STORMWATER MANAGEMENT PLAN (SWMP)

MAYBERRY, COLORADO SPRINGS – FILING NO. 2A

**R&R JOB #MC22199
EPC PROJECT No. SF1910**

**SITE MAP**  
SCALE 1" = 500'

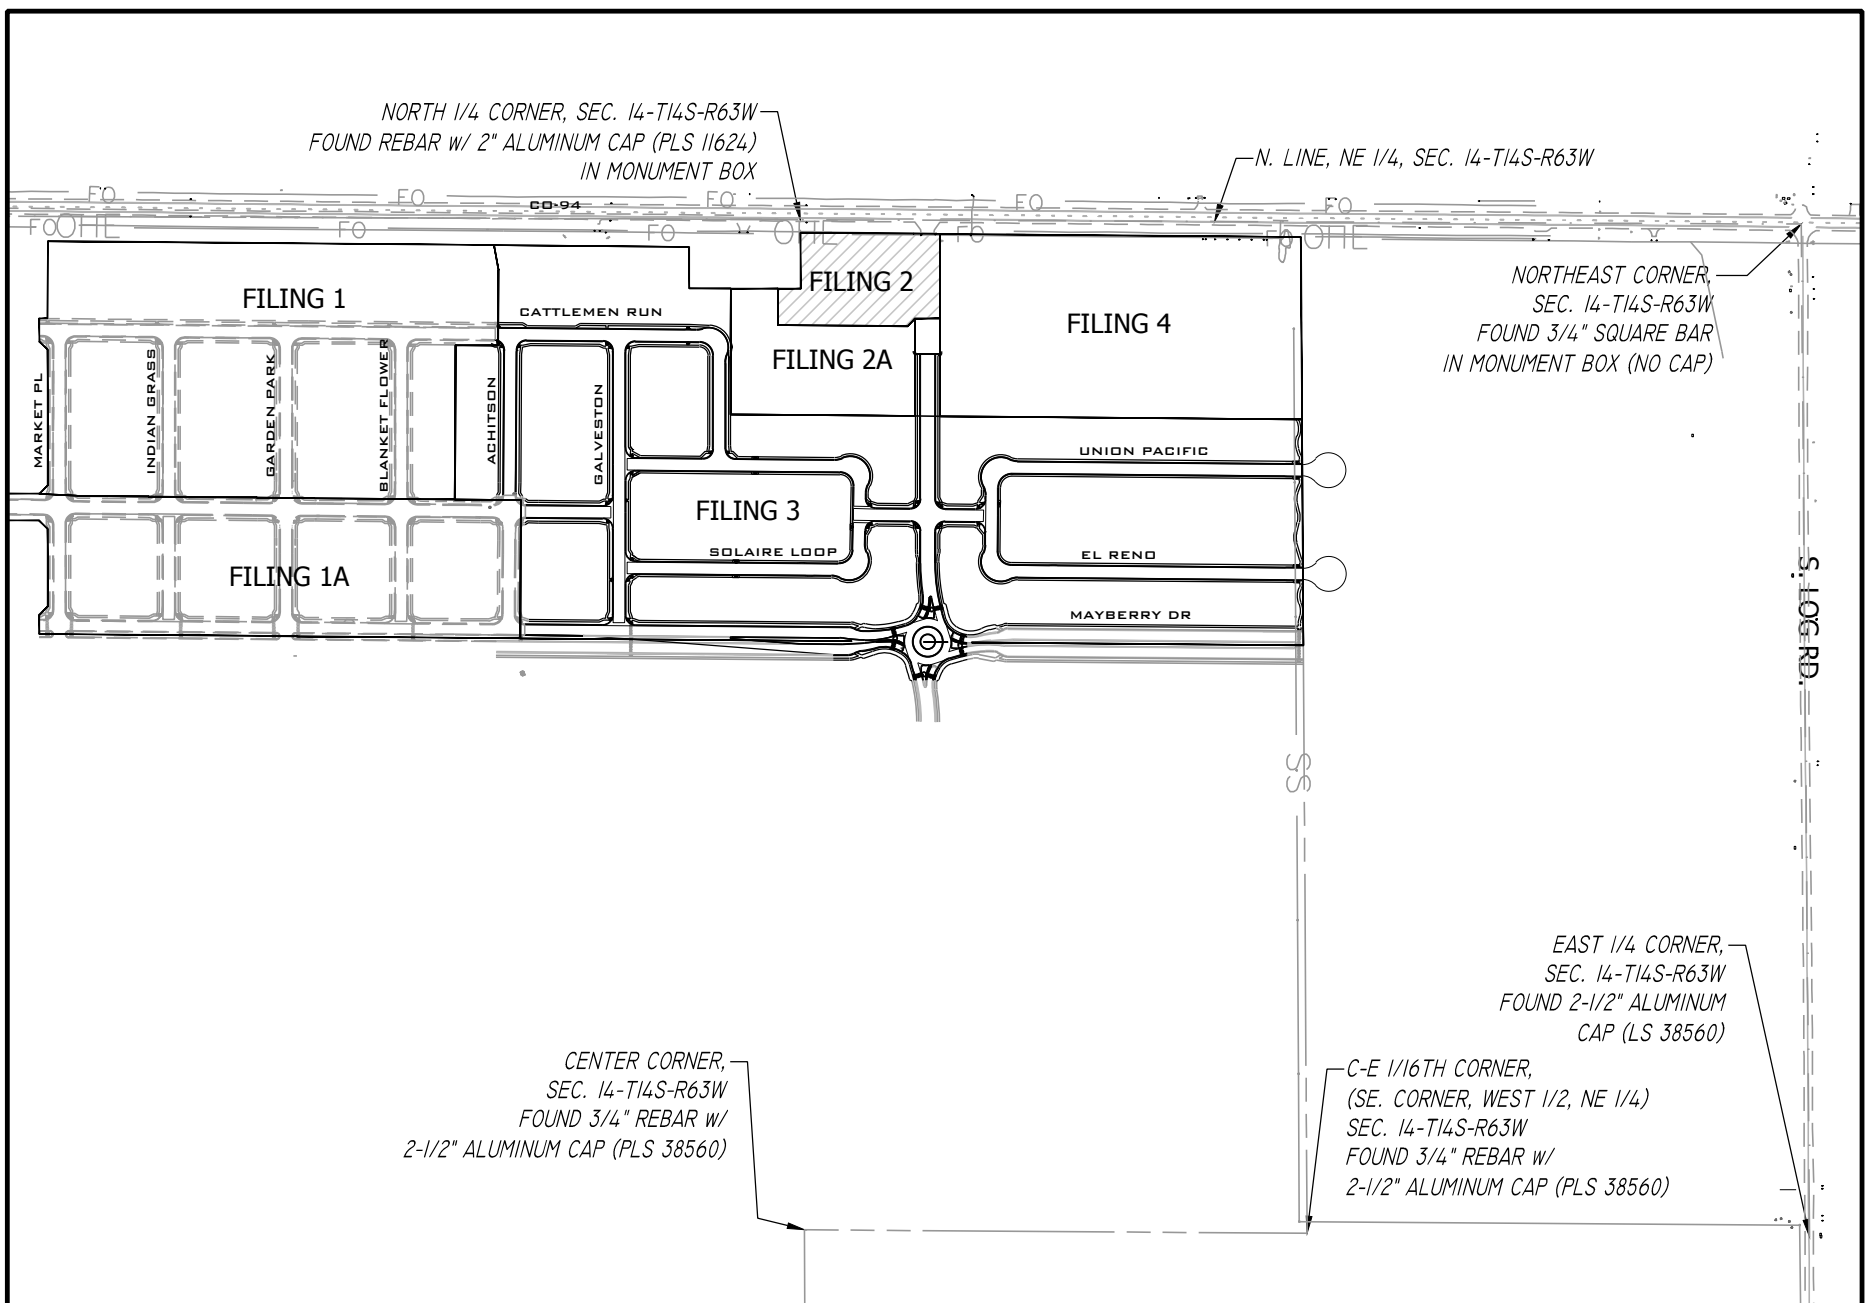
SWMP Checklist Item 1 - put QSM and Contractor info on cover/title sheet (if TBD leave a placeholder)

QSM and Contractor info now provided.
